# OBSERVATION/SUBMISSION TO PLANNING APPLICATION

Case Reference: 324113

**Re: Observation to the proposed development of open-cycle gas turbine (OCGT) and generator with ancillary equipment.**

Location: Pollnagroagh and Rathmorrissy (Townlands), Athenry, Co. Galway

Purpose		PLANNING			
Title		SITE ACCESS SIGHTLINES			
Original Scale	Design/Drawn	Checked	Authorised		
SHOWN at A1	PS	ND	AJB		
Date	Date	Date	Date		
01.12.25	01.12.25	01.12.25	01.12.25		
Status	Drawing Number	Rev			
A2	PEK3-ATK-ZZ-01-DR-CE-901200	0

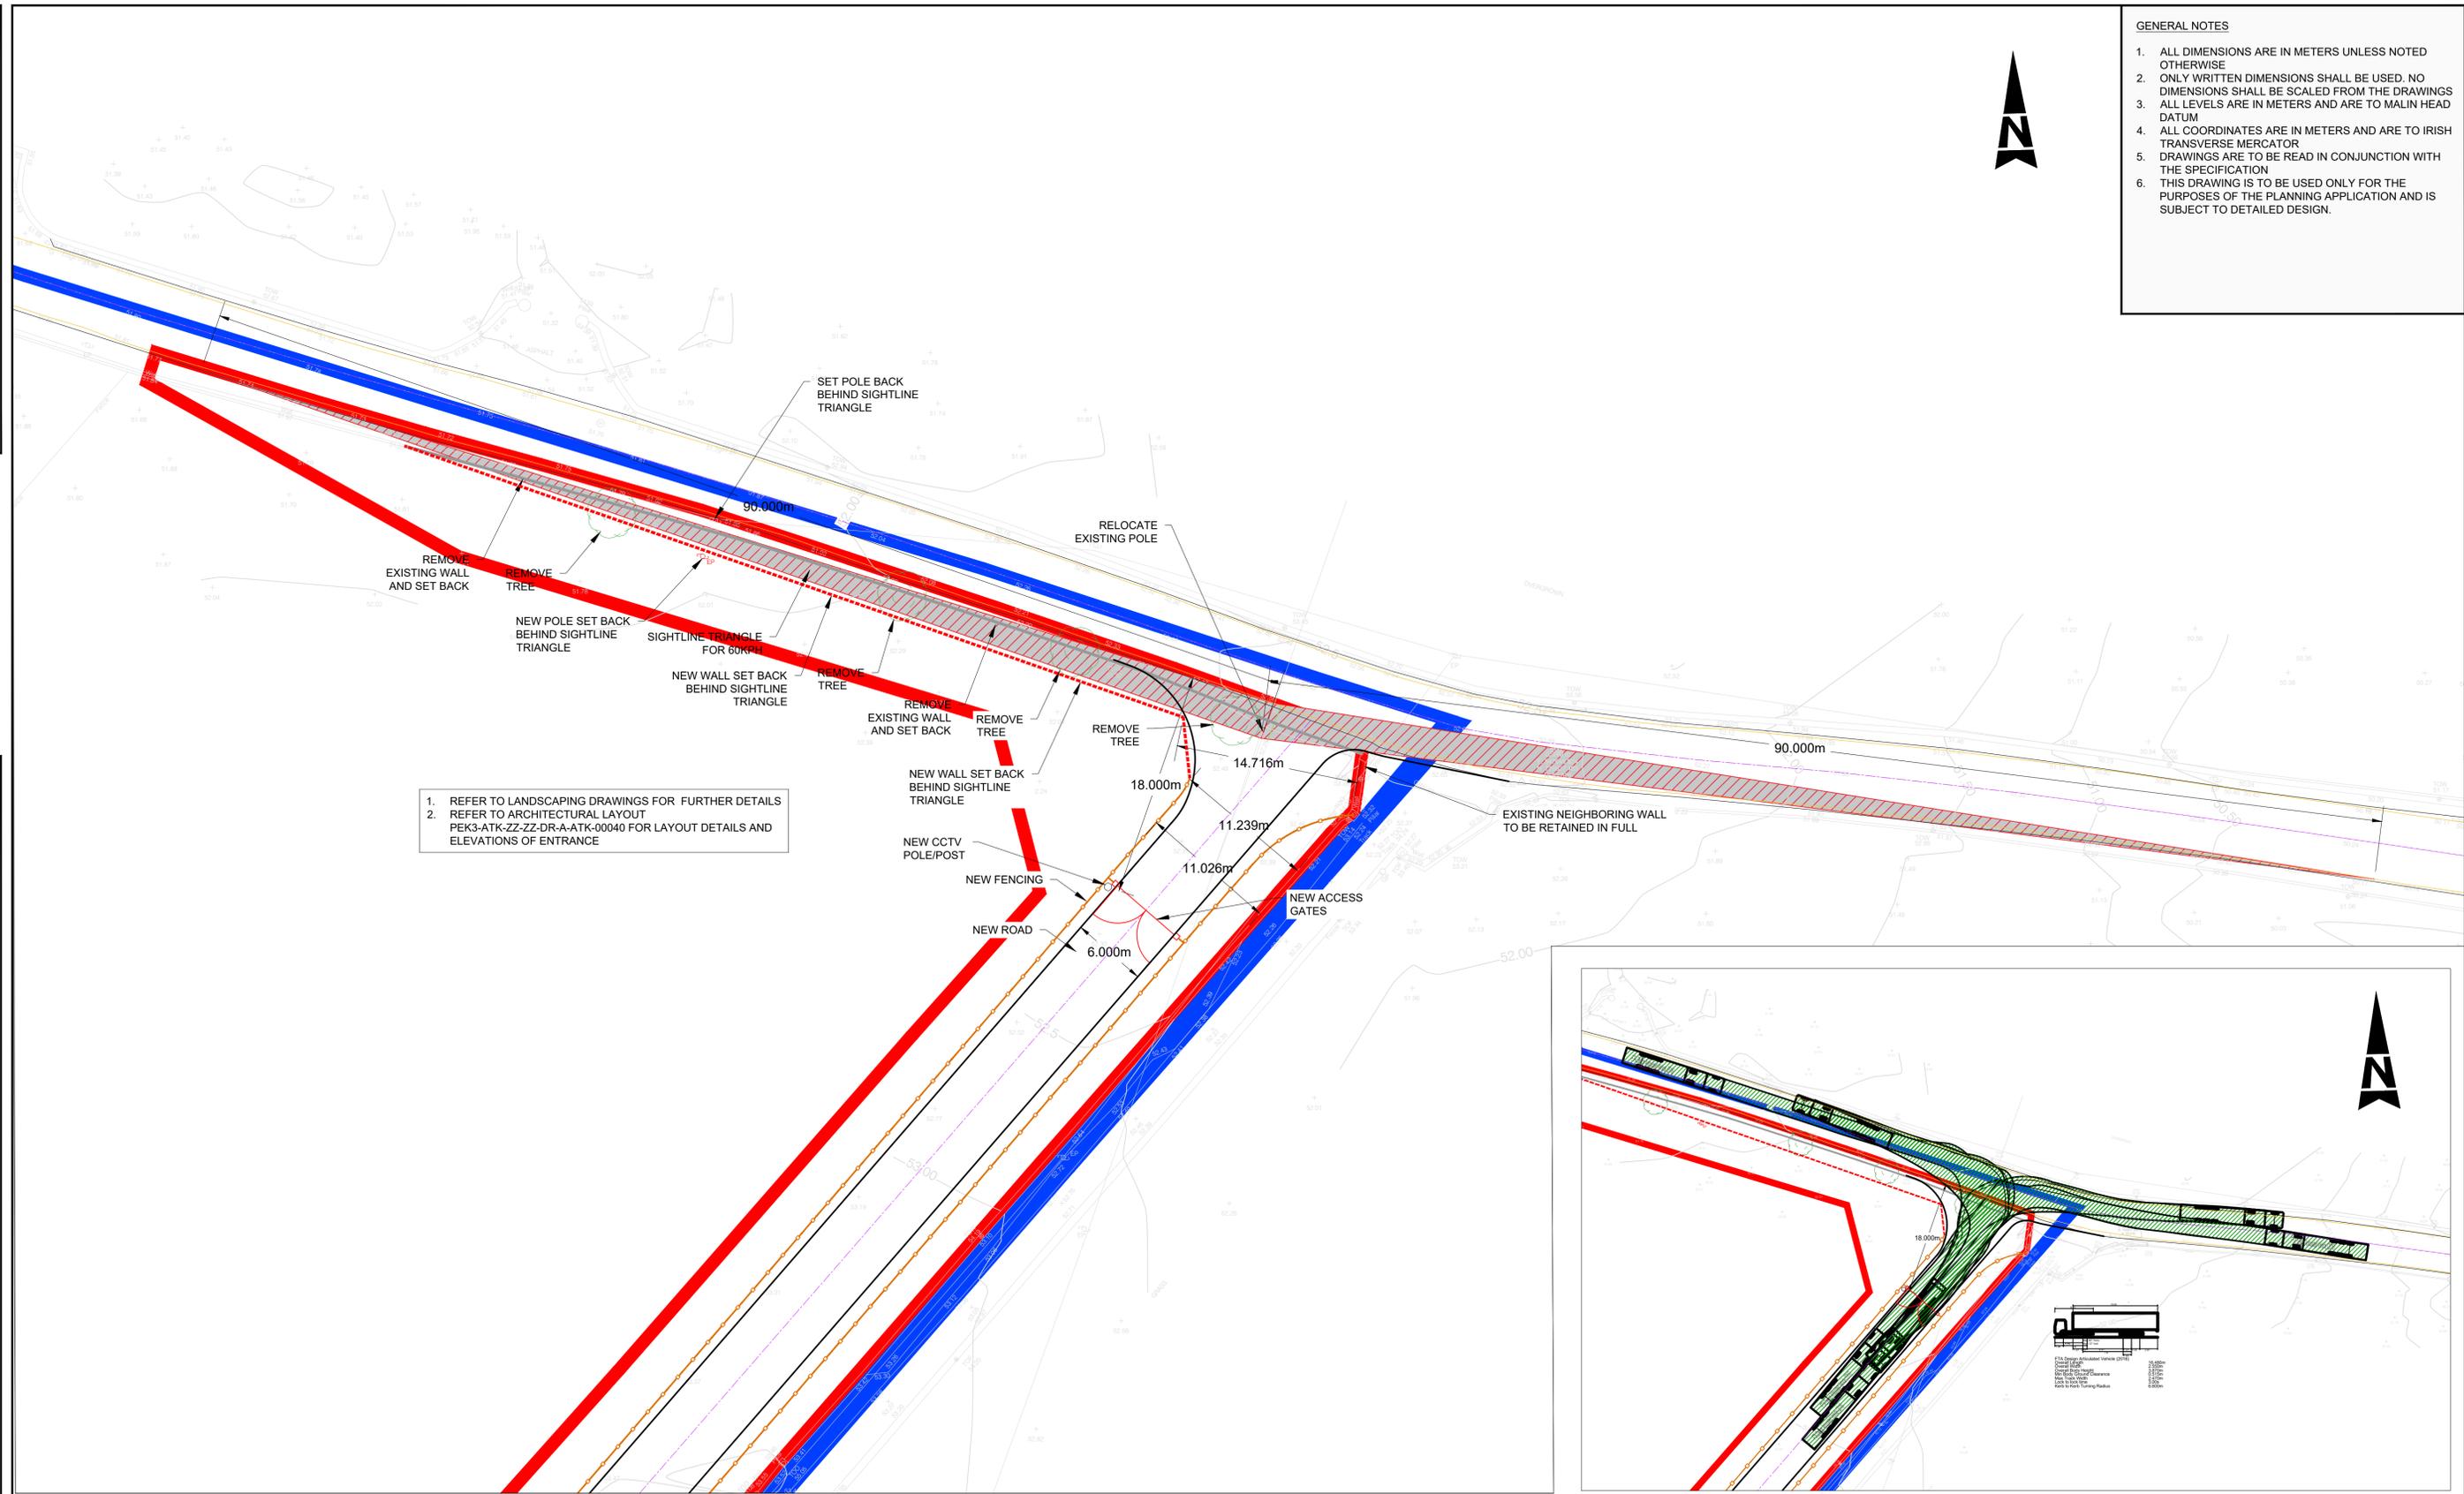
As someone who lives locally and uses this road, I am concerned about road safety in relation to the proposed entrance on the L3103. This stretch of road is already extremely narrow, with no hard shoulder, making it difficult for two heavy goods vehicles to pass safely and leaving no margin for error. Visibility is also poor due to blind dips and sharp bends, meaning drivers often cannot see oncoming traffic in time. The proposed development would increase traffic levels, including heavy goods vehicles, construction traffic, and fuel deliveries such as diesel tankers, all of which require space and clear sightlines that this road does not provide.

As someone who lives locally and extensively uses this road, I am concerned about the proposed location of the site entrance on the L3103. This section of road is already extremely dangerous, as it is narrow, has no hard shoulder, and does not provide sufficient space for two heavy goods vehicles to pass safely. Visibility is also poor due to blind dips and sharp bends, meaning drivers often cannot see oncoming traffic in time, and introducing a site entrance at this location would significantly increase the risk to all road users.

There are serious concerns about the proposed site entrance on the L3103, which is an exceptionally dangerous stretch of road where introducing an access point would create an unacceptable level of risk. The road is extremely narrow and cannot safely accommodate two heavy goods vehicles passing at the same time, there is no hard shoulder to allow for safe manoeuvring or recovery, and visibility is severely limited due to blind dips and sharp corners. These are significant existing hazards that already pose a real danger to road users, and the addition of a site entrance would further increase that risk.

The placement of a site entrance at this hazardous location on the L3103 raises serious safety concerns. The road is already constrained by its narrow width, the absence of a hard shoulder, and extremely poor visibility due to blind dips and sharp corners, yet the Environmental Impact Assessment does not appear to fully address the safety implications of introducing an access point at this location. There are also concerns that the cumulative impact of additional traffic has not been properly assessed, including construction traffic, ongoing operational traffic, and fuel deliveries, and the interaction between heavy goods vehicles and existing road users—such as local traffic, school-related movements, and agricultural machinery—has not been examined in sufficient detail. Overall, the lack of a thorough and robust traffic safety assessment creates significant uncertainty as to whether the local road network can safely accommodate this development.
